WEST SUSSEX COUNTY COUNCIL CONSULTATION

TO:	Arun District Council FAO: Michael Eastham
FROM:	Stephen Gee Highways, WSCC
DATE:	20/04/18
LOCATION:	Manor Nursery, High Street, Angmering, BN16 4AW
SUBJECT:	A/38/18/RES Approval of reserved matters following outline consent A/51/14/OUT relating to appearance, landscaping, layout & scale for demolition of the existing Manor Nursery Garden Centre & hard standing & redevelopment for 32No. dwellings with associated access, public open space & landscaping.
DATE OF SITE VISIT:	20/04/18
RECOMMENDATION:	☐ Advice ☐ Objection ☒ Modification ☐ No Objection ☒ More Information ☐ Refusal
S106 CONTRIBUTION TOTAL:	£ See below for breakdown.

The application is for the approval of reserved matters in relation to the development of 32 dwellings at Manor Nursery, High Street, Angmering.

DENNIS SABRE FIRE TENDER (LWB)
TRACKING AROUND THE SITE
SCALE 1:250

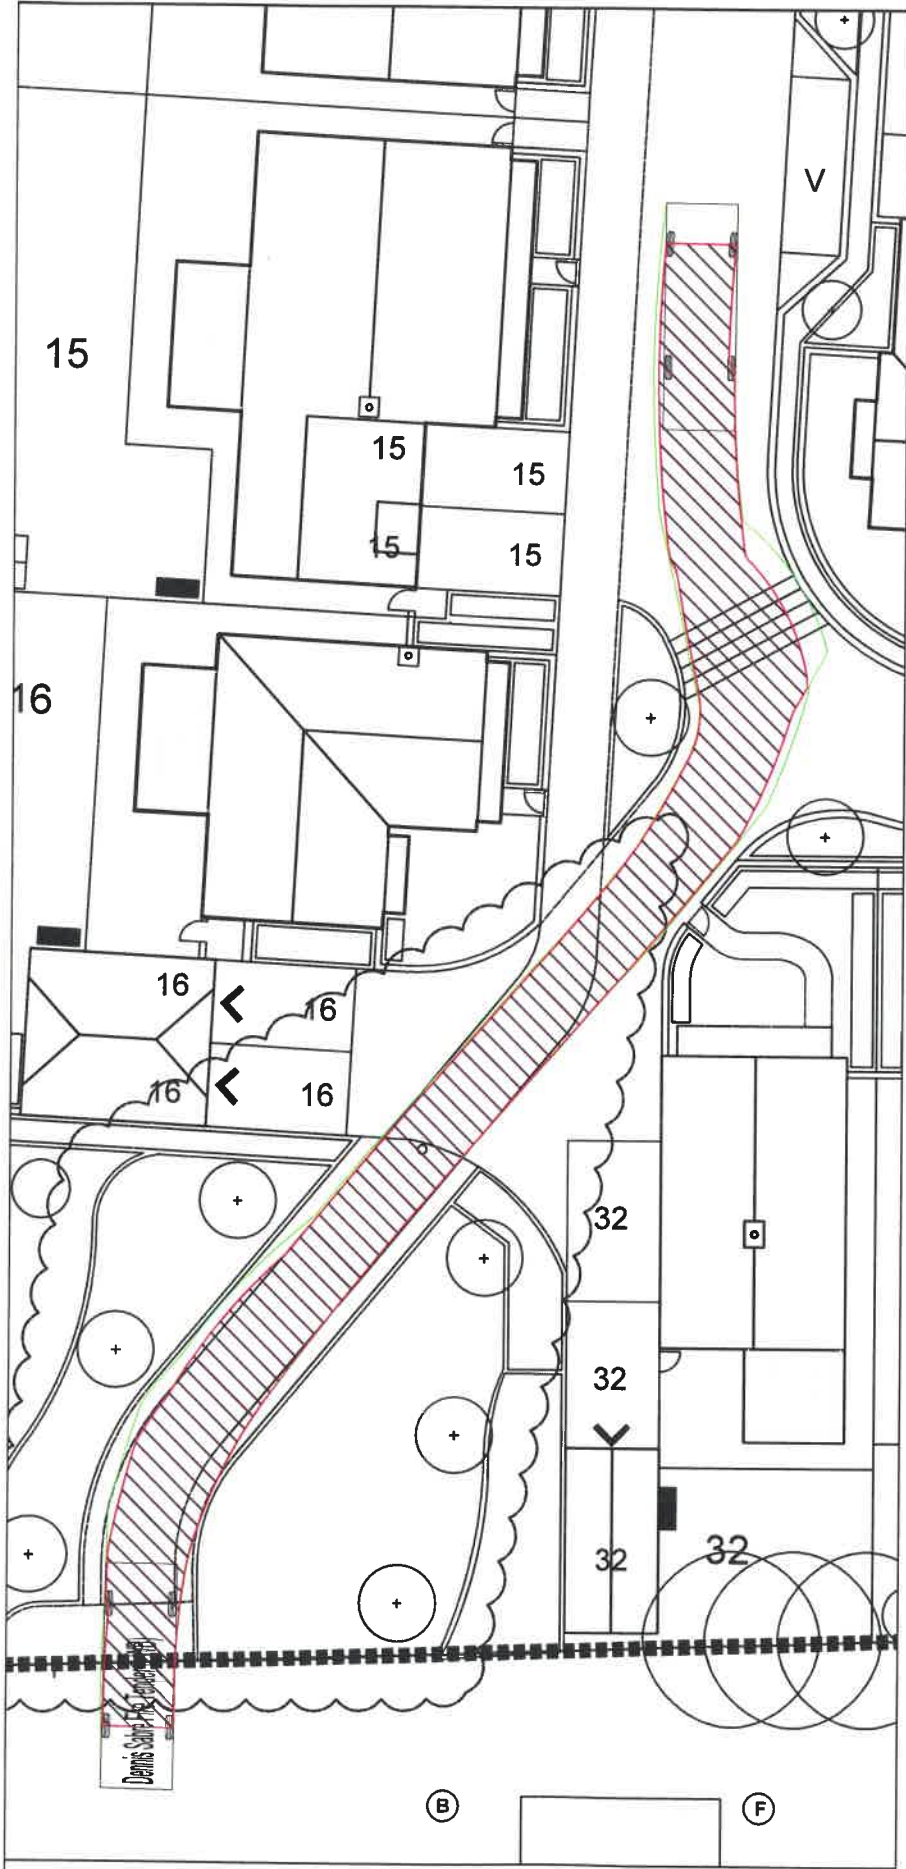
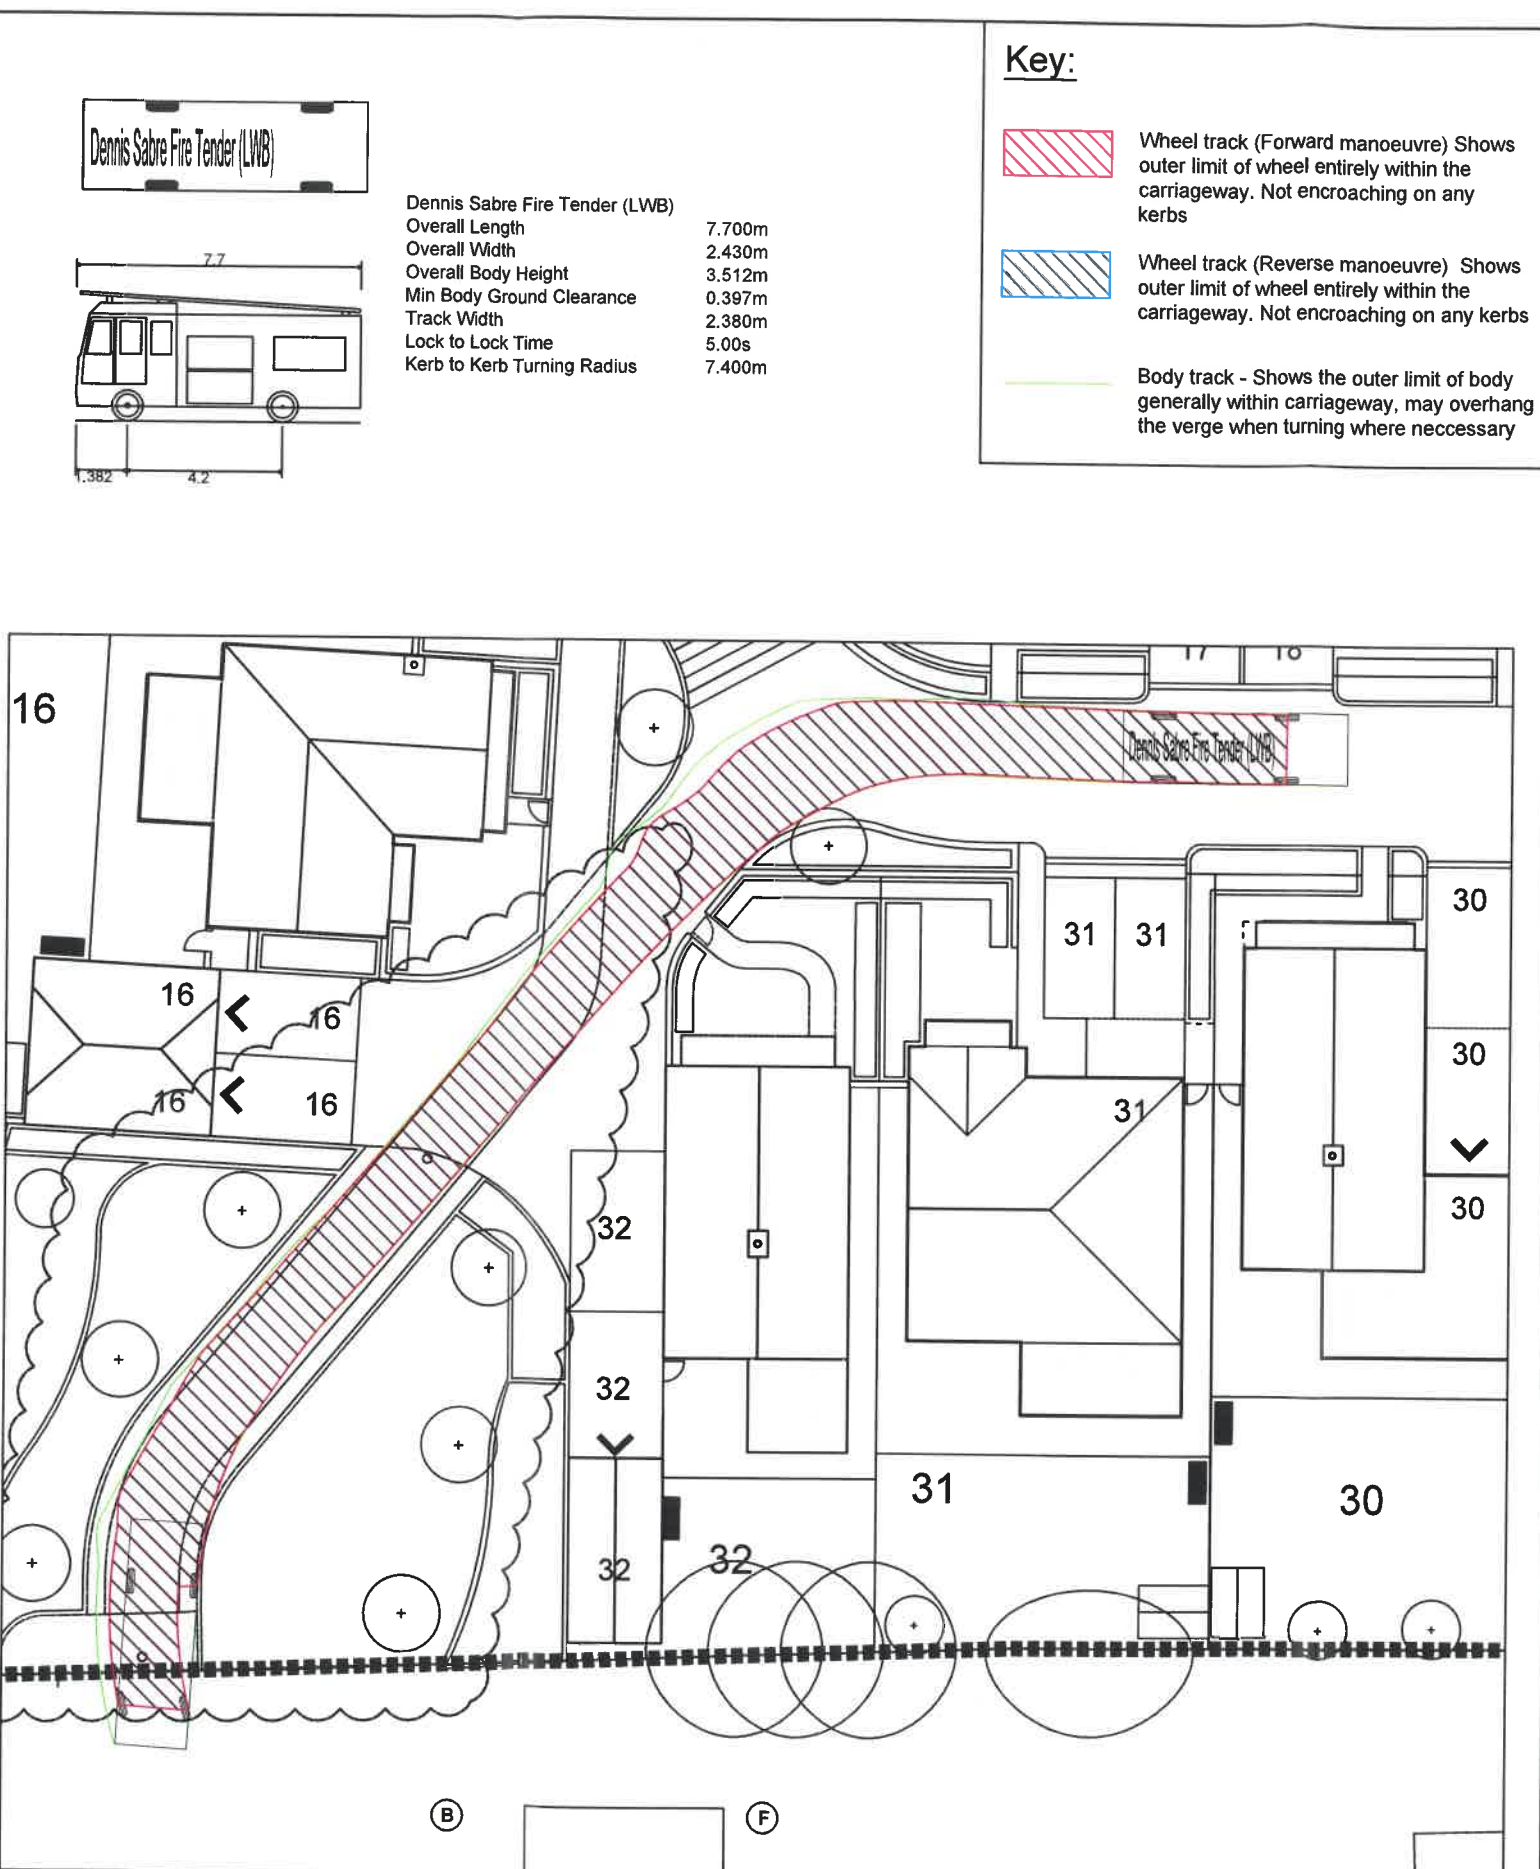
Vehicle tracking for a fire tender and refuse vehicle have been provide are accepted.
